Site plans - building permit

4.) Revised Site Plans – We can upload the revised site plans (dated 5/15) to the application website as a separate file. Revisions to plans are:

5.) Response from Sebago to DPW comments (From Bradley Lyon)

PROJECT NO.	SCALE
15466	1" = 5'
SHEET 2 OF 16

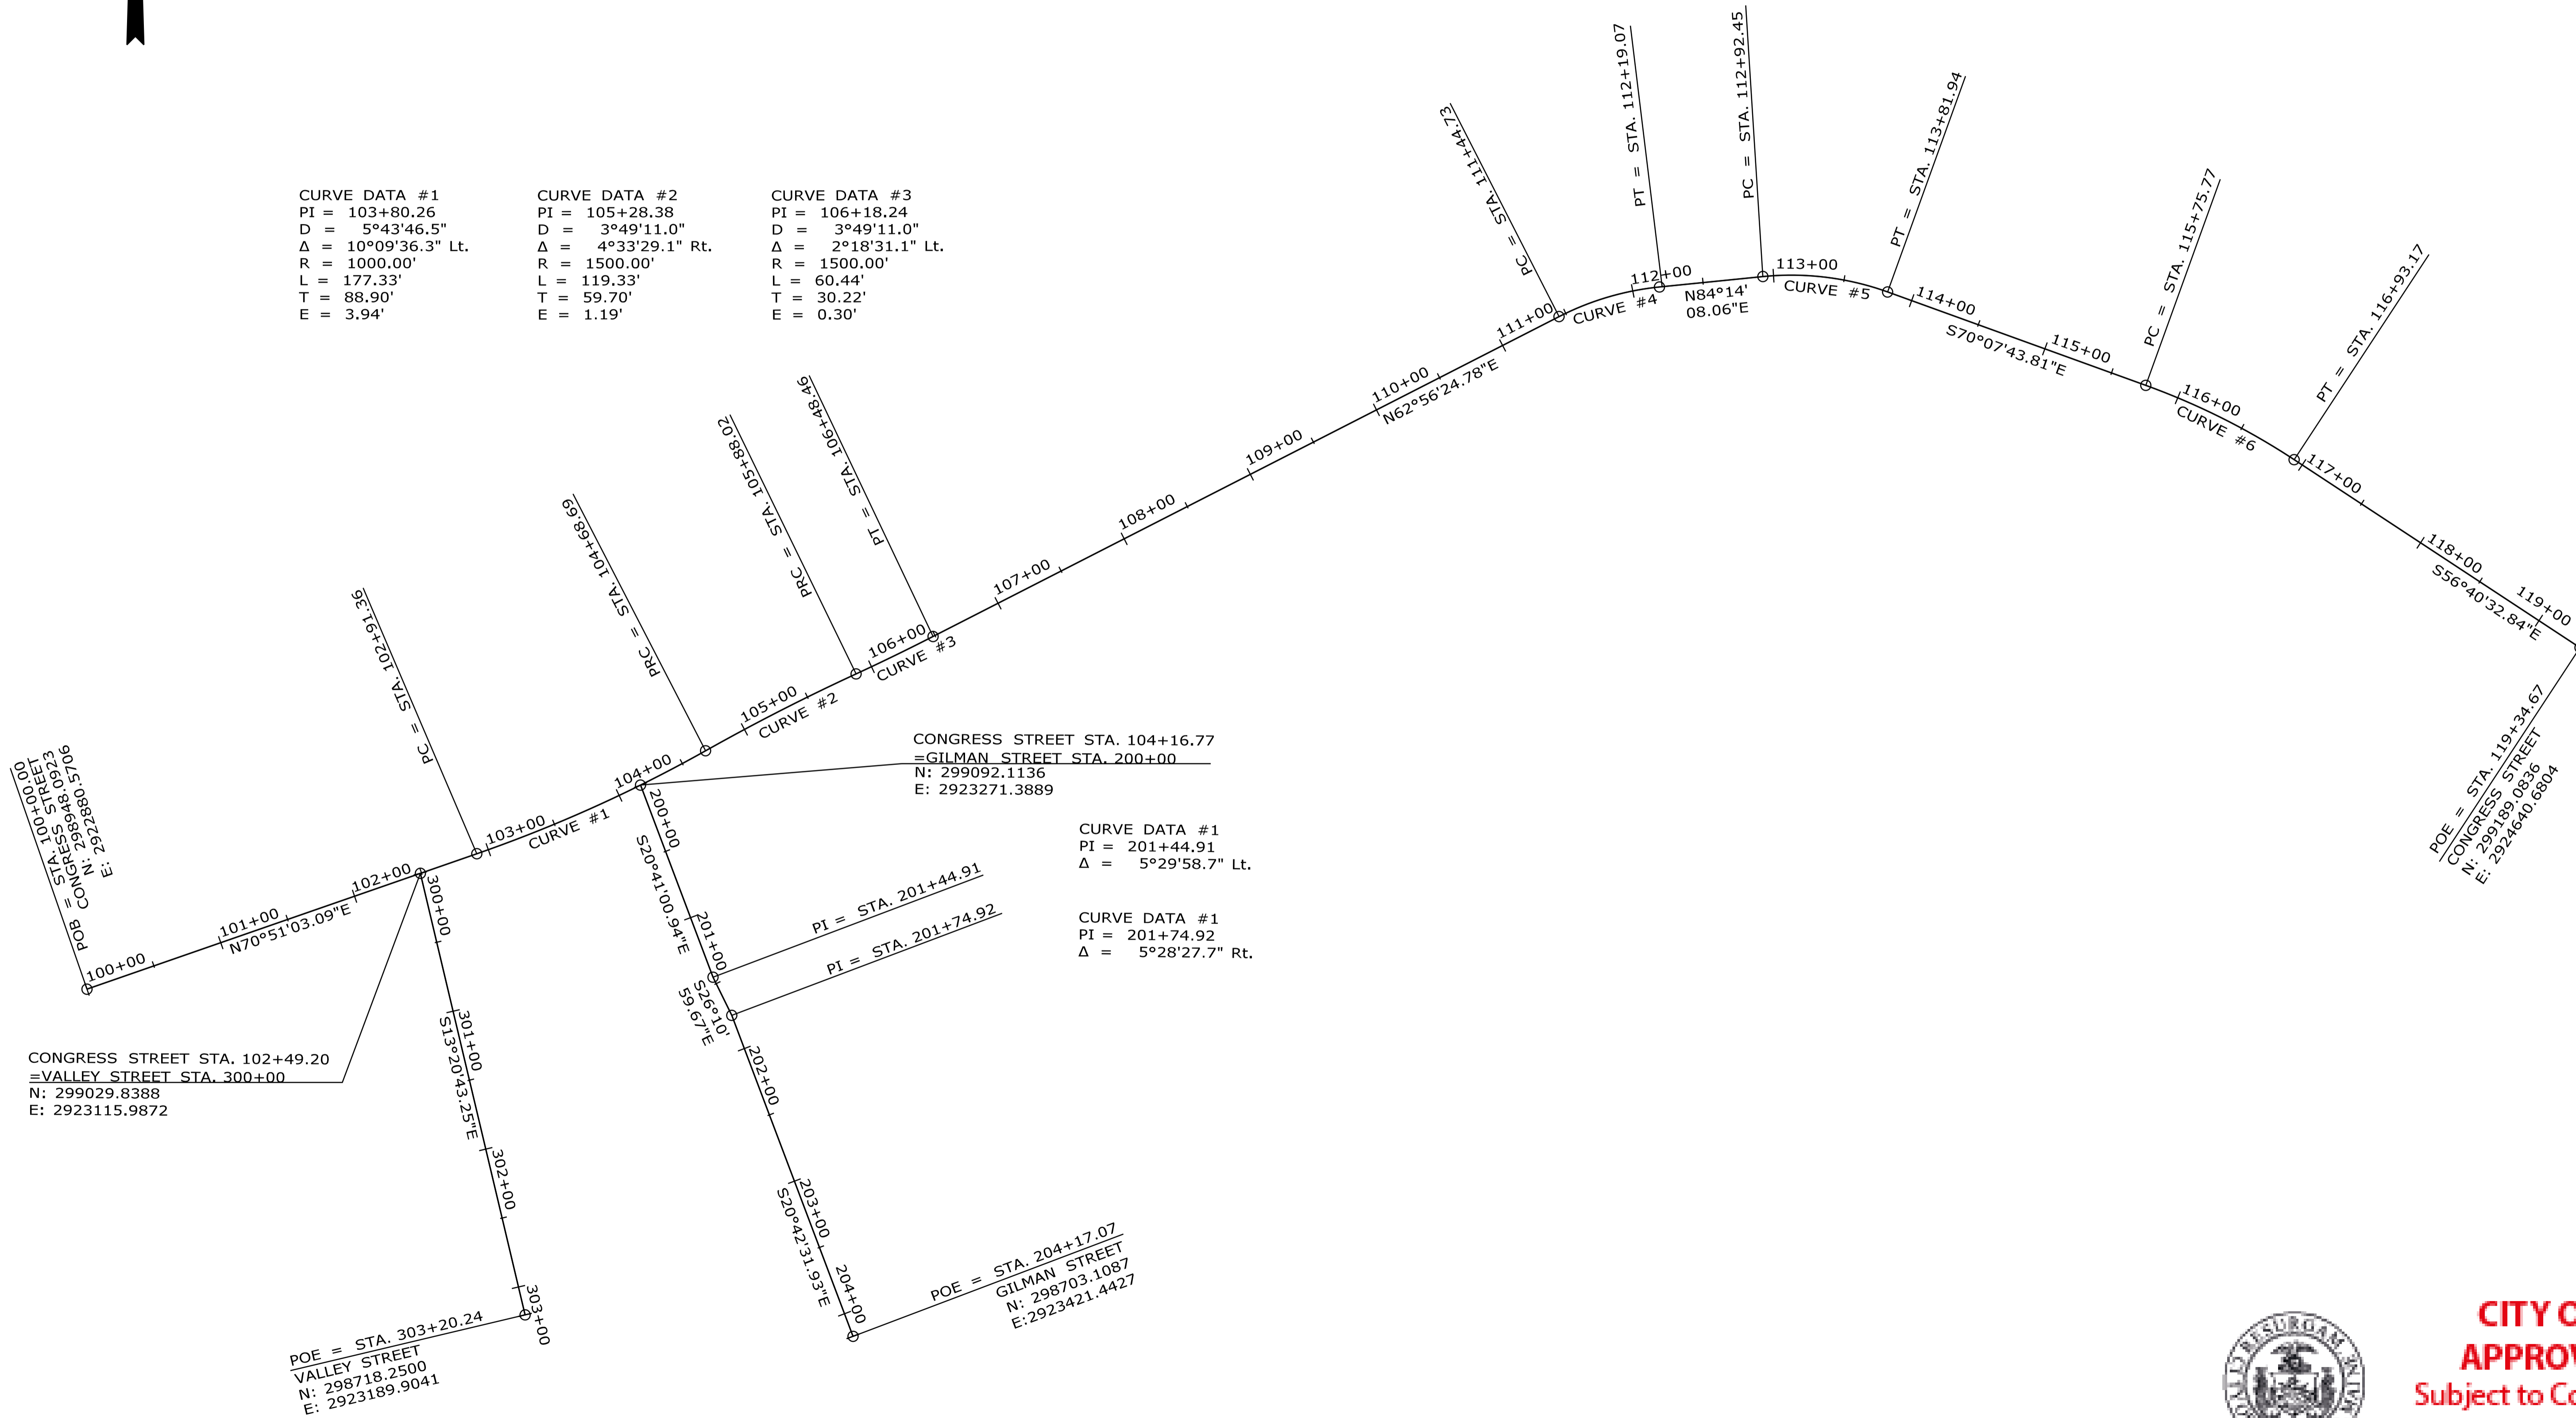
- The plans do not indicate a phased approach to the street improvements. At a minimum, the improvements shown on the west side of the Congress/Valley intersection should be completed PRIOR to removal of the signal here. Please document on the plans and in the CMP. *Note 3 on Sheet 4 has been added addressing this condition.*

PAVEMENT MARKING & SIGNING PLAN  
CONGRESS STREET IMPROVEMENTS  
PROJECT LOCATION: MEDICAL CENTER  
22 BRADSHAW STREET  
PORTLAND, ME 04102

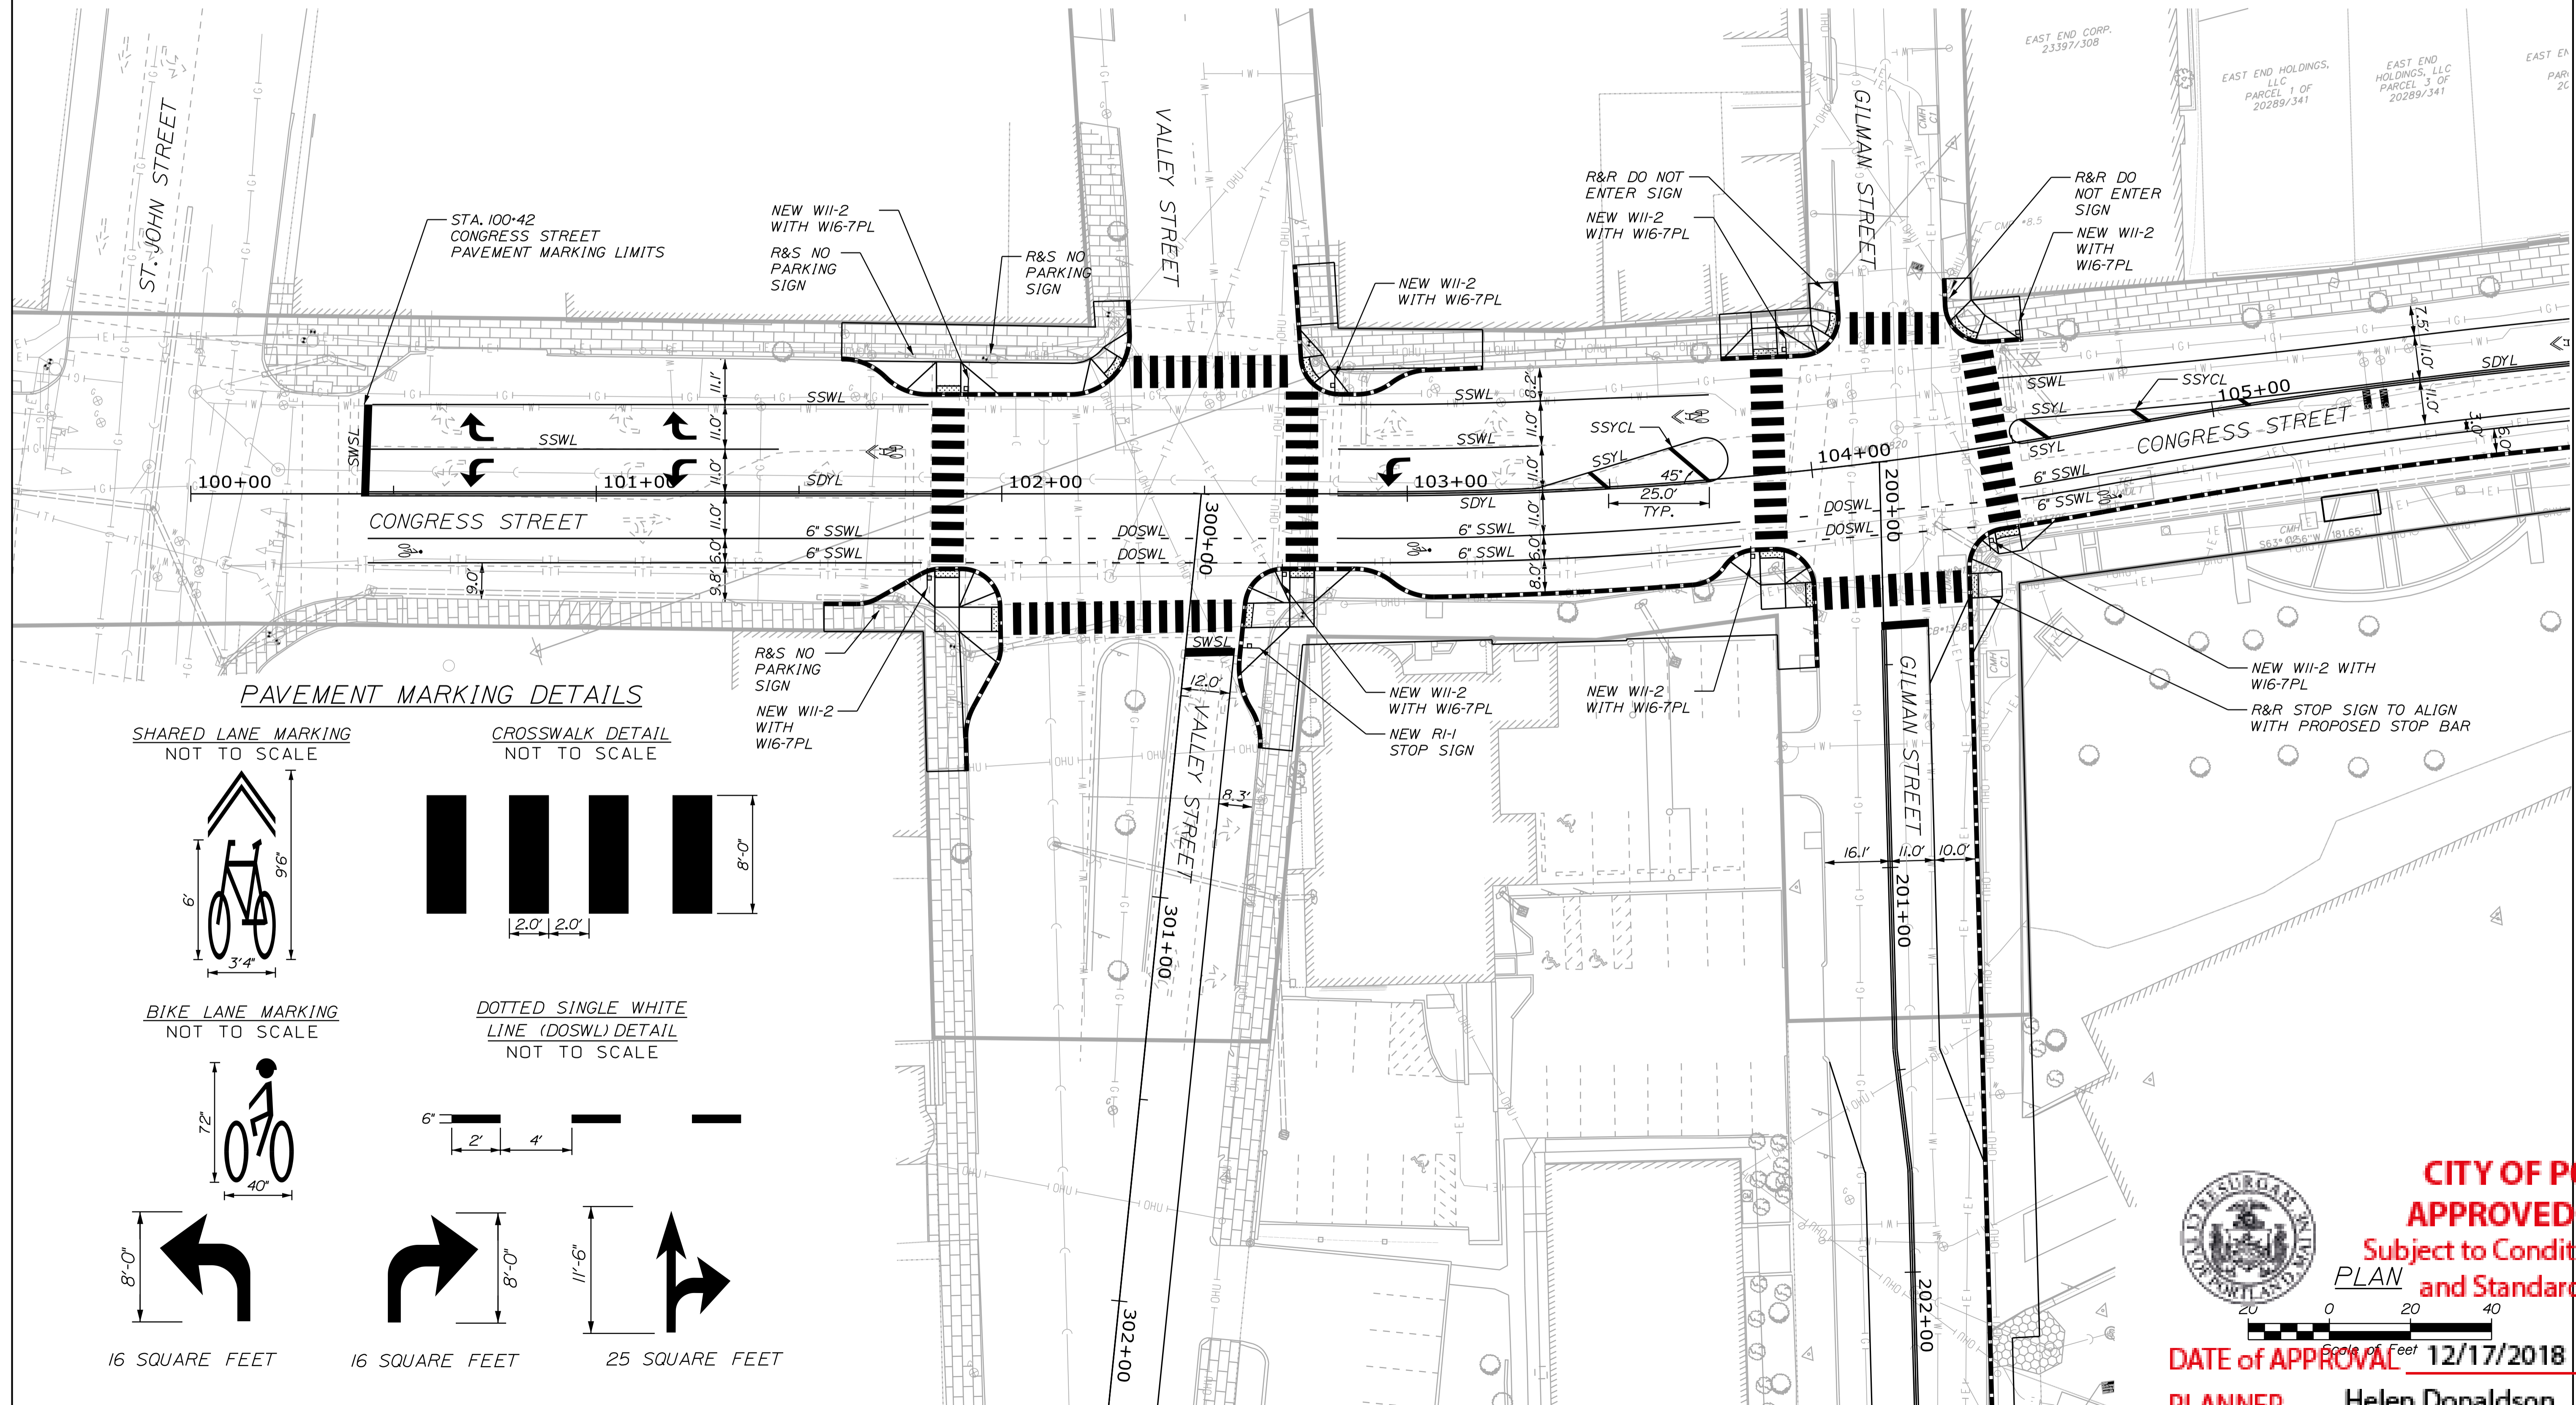
- The symbol for bicycle lanes should show the City and MUTCD standard helmeted cyclist. *Based on an email from you earlier this week we understand you are moving away from the detail shown in your Technical Manual and heading more towards the standard bike symbol in the MUTCD. Our plans have been updated to show this.*
